Our ref: SL/2018/118397/04-L01
Your ref: EN010093
Date: 20 May 2019

WRITTEN REPRESENTATIONS.

**Application by Cory Riverside Energy for an order granting development
consent for the Riverside Energy Park - Riverside Energy Park, Belvedere,
South East London**

Written Representations on behalf of the Environment Agency

Date	13.05.19
A1 Scale	1:250
Drawn by	AG
Checked by	PC
Drawing Number	VAA-WA-50080101_1.0

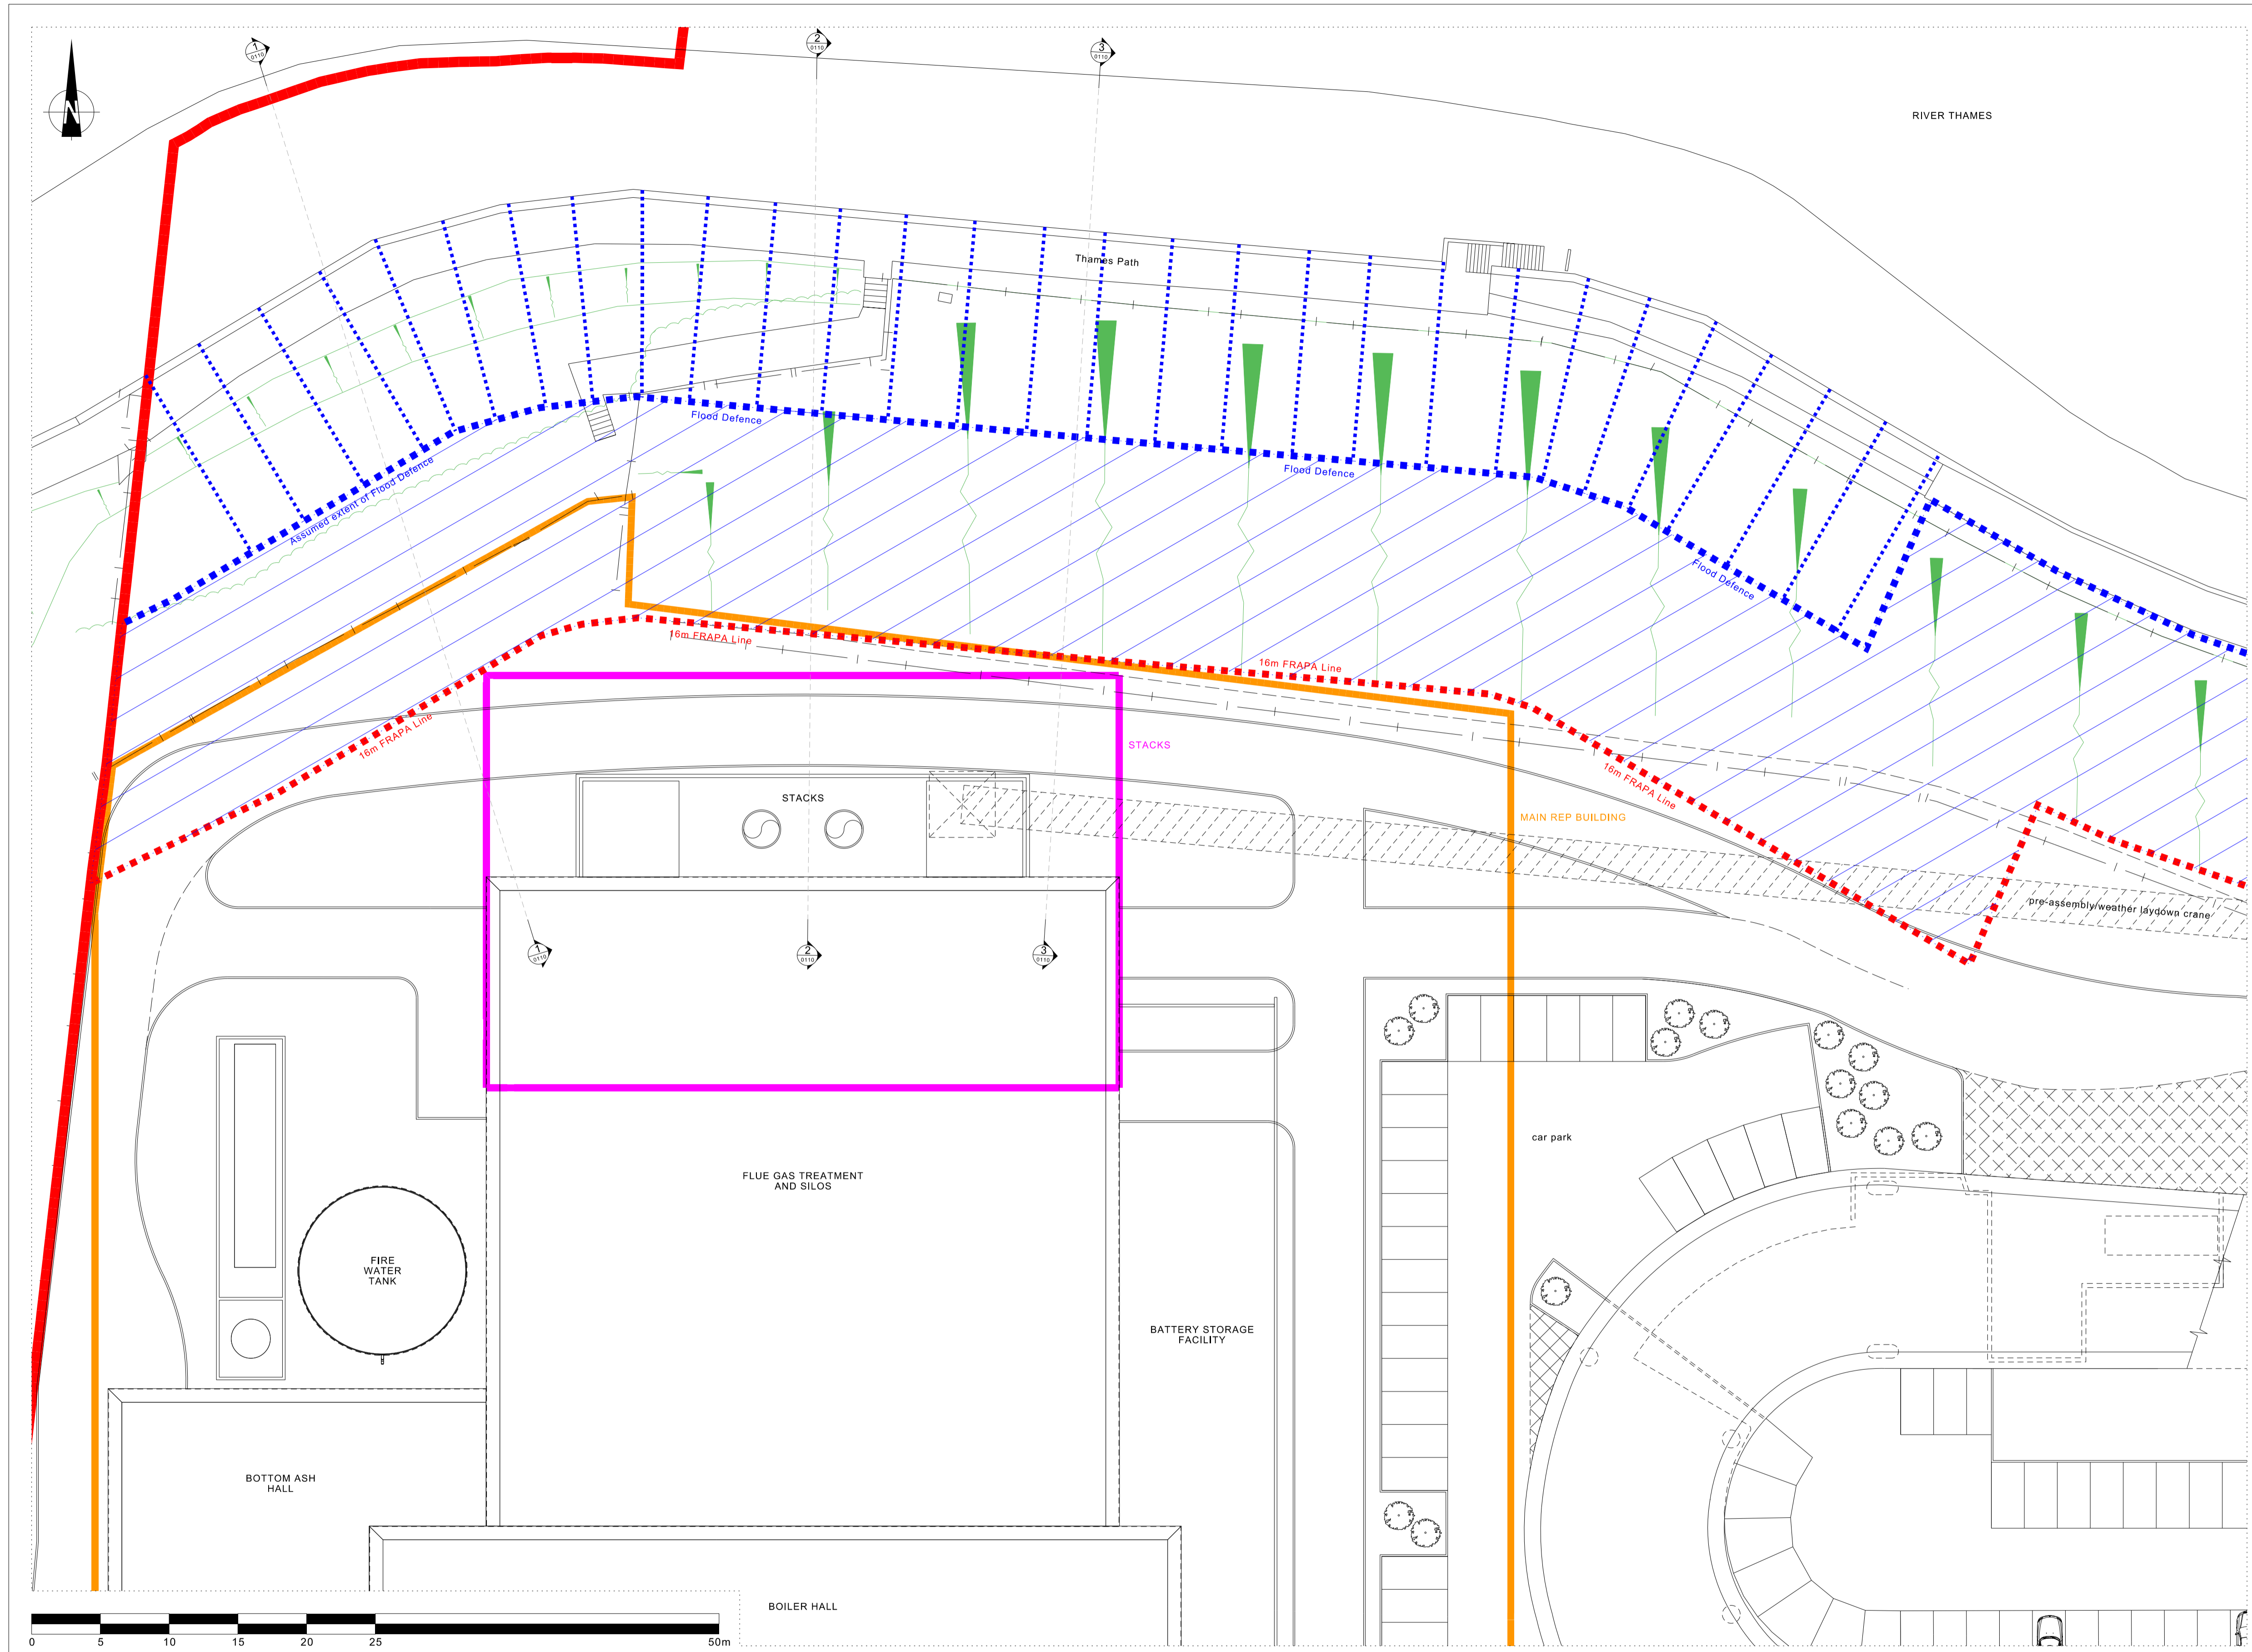
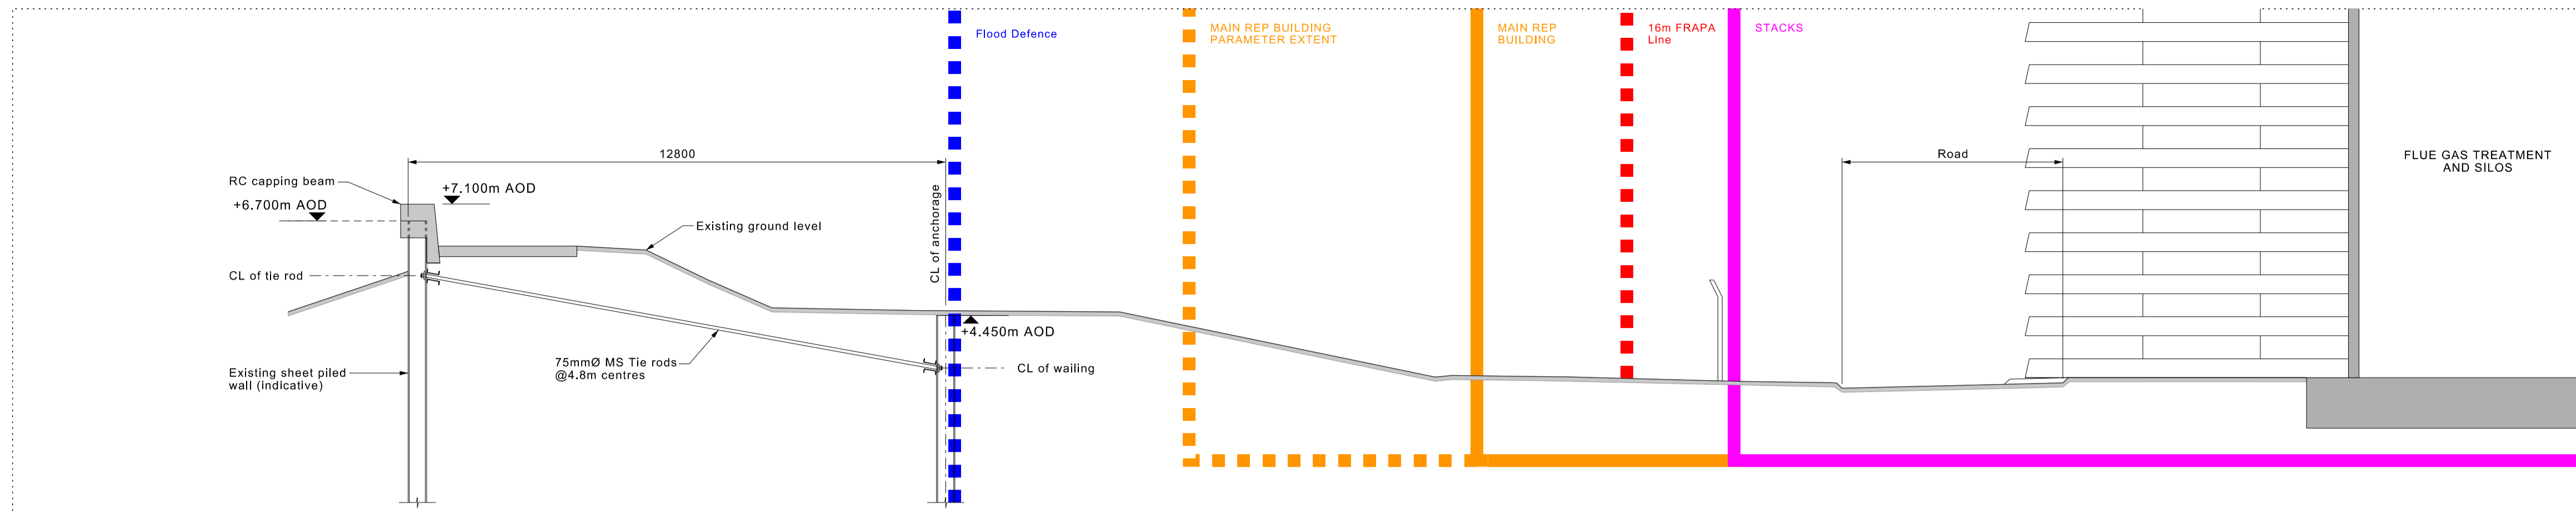
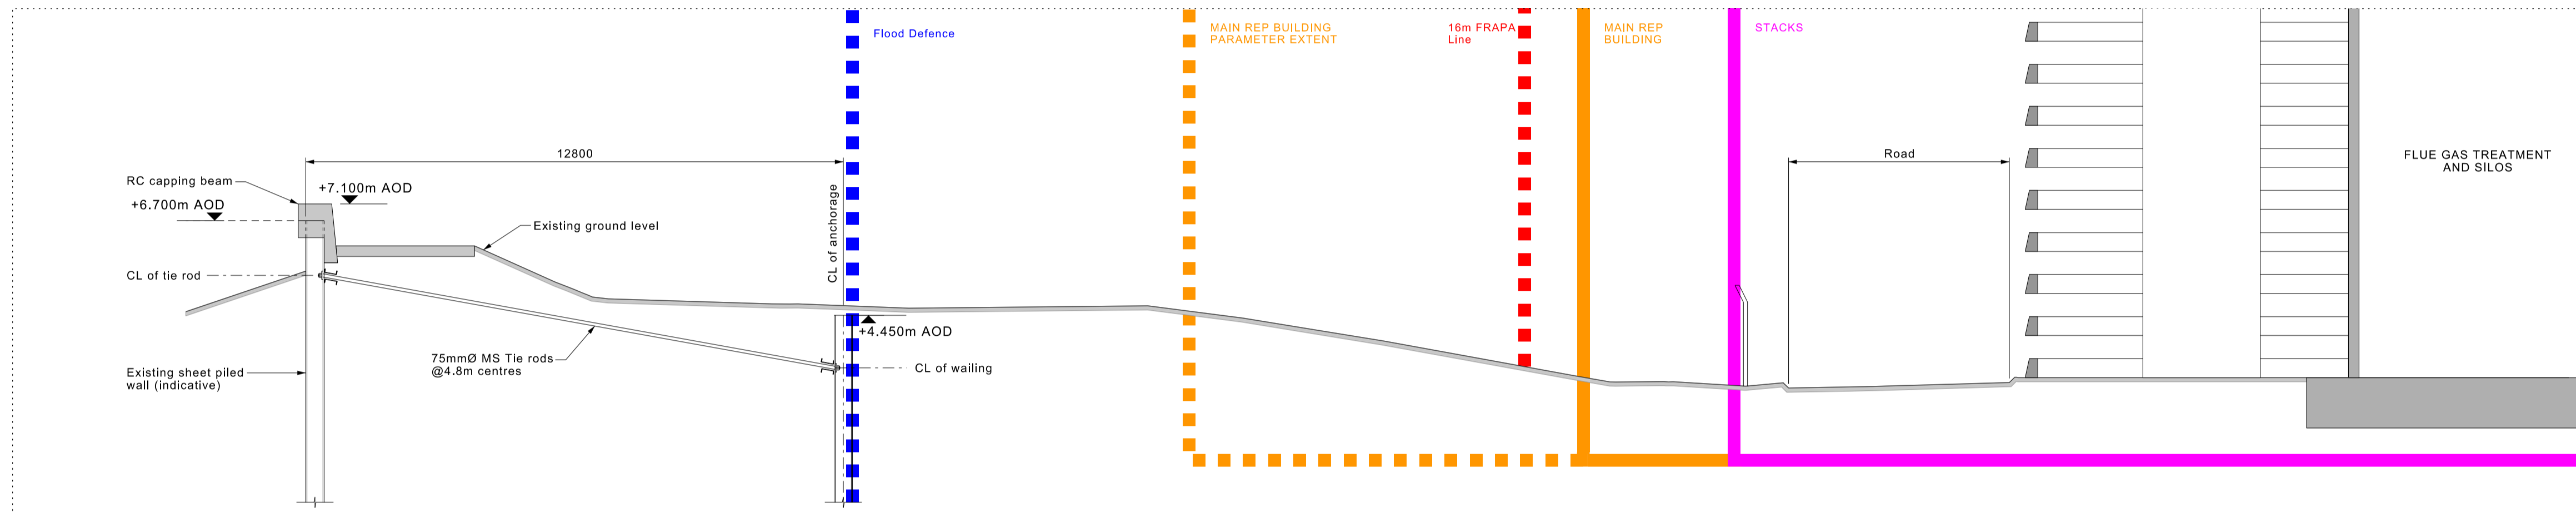
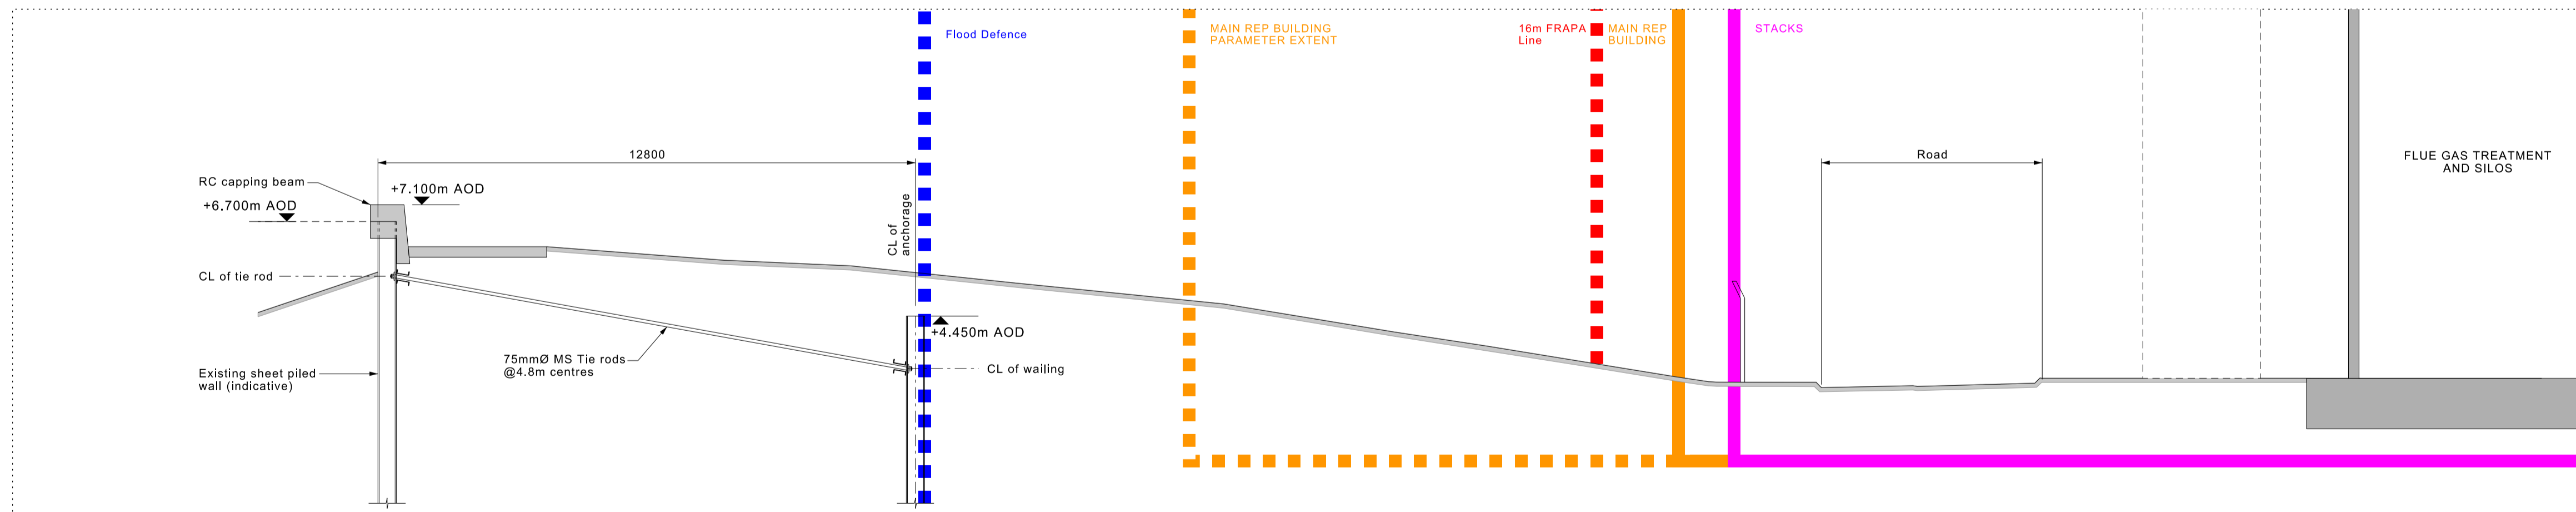
Requirement 2 - No buildings shall be erected or material stored which could create a risk of damage to the flood defence structure within the area defined by the red dotted line annotated as '16m FRAP Line' on Weedon Architects drawing 'DCO Boundaries and FRAP Area Indicative Building Layout' number VAA-WA-50080101_1.0 dated 23.03.19

Reason – To preserve open space for possible future works to the Thames Tidal Flood Defences as agreed in the statement of common ground.
